I have reviewed the Application for the Sunset Farms Preliminary Plat (P-07-60). This proposed plat is located well over 5 miles from the nearest staffed fire station and is subject to extended fire and emergency medical service response times. This information is provided for information purposes for the developer / owner. During development, the following issues will need to be addressed:

RE: Sunset Farms Preliminary Plat (P-07-60)

TO: Trudie Pettit, Community Development Services  
FROM: Christina Wollman, Planner II *CW*  
DATE: April 10, 2008  
SUBJECT: Sunset Farms Plat P-07-60

**SITE PLAN  
OF  
SUNSET FARMS**

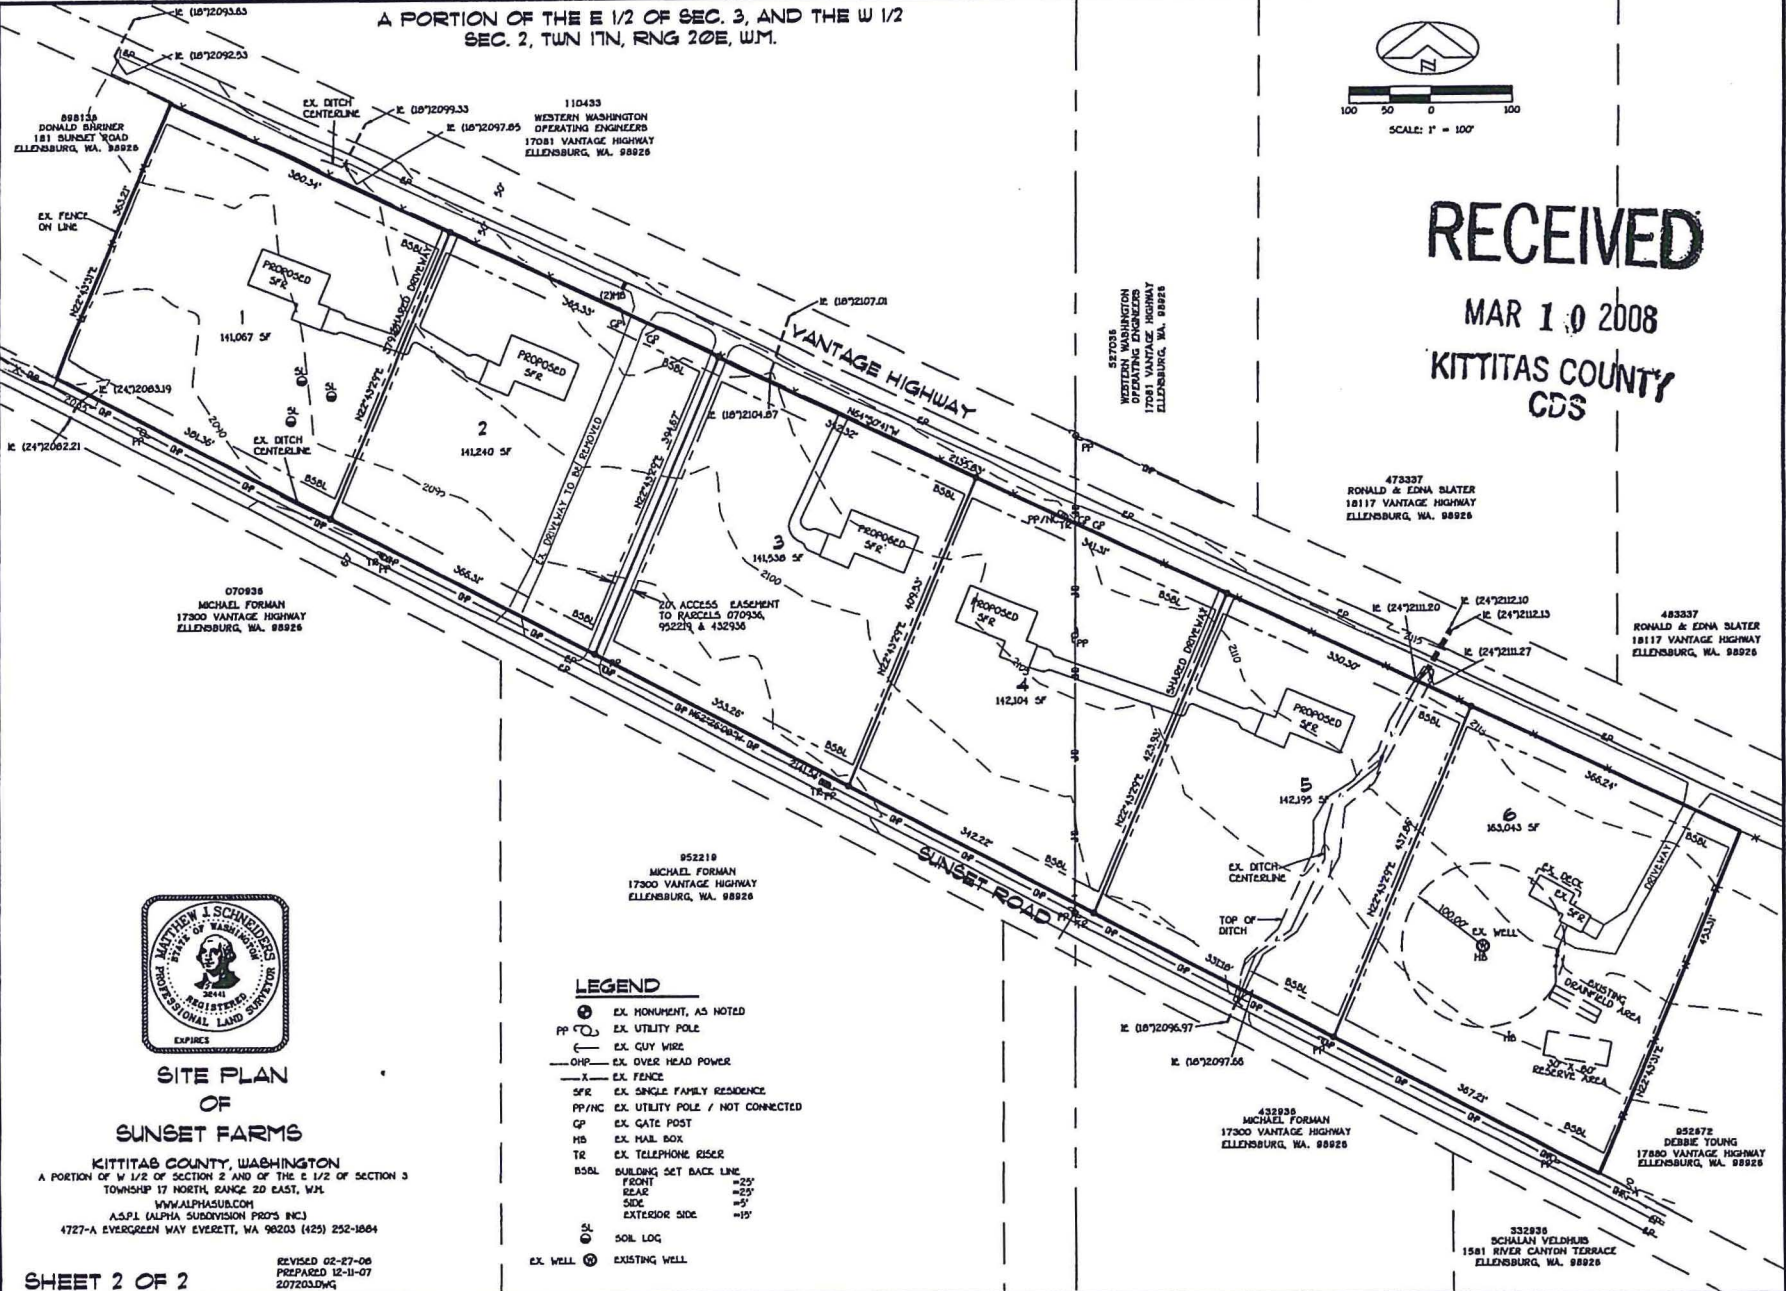
1. **Access Spacing:** Vantage Highway is classified as a Rural Minor Collector and has a minimum access spacing of 300'. The most current survey, dated February 27, 2008, does not meet this requirement. The access to Lot 3 is less than 300' from the 20' easement.

3. **20' Access Easement:** The AFN for the 20' access easement shall be shown on the face of the plat.
4. **Joint-Use Driveway:** A joint-use access shall serve no more than two tax parcels. See Kittitas County Road Standards, 9/6/05 edition.
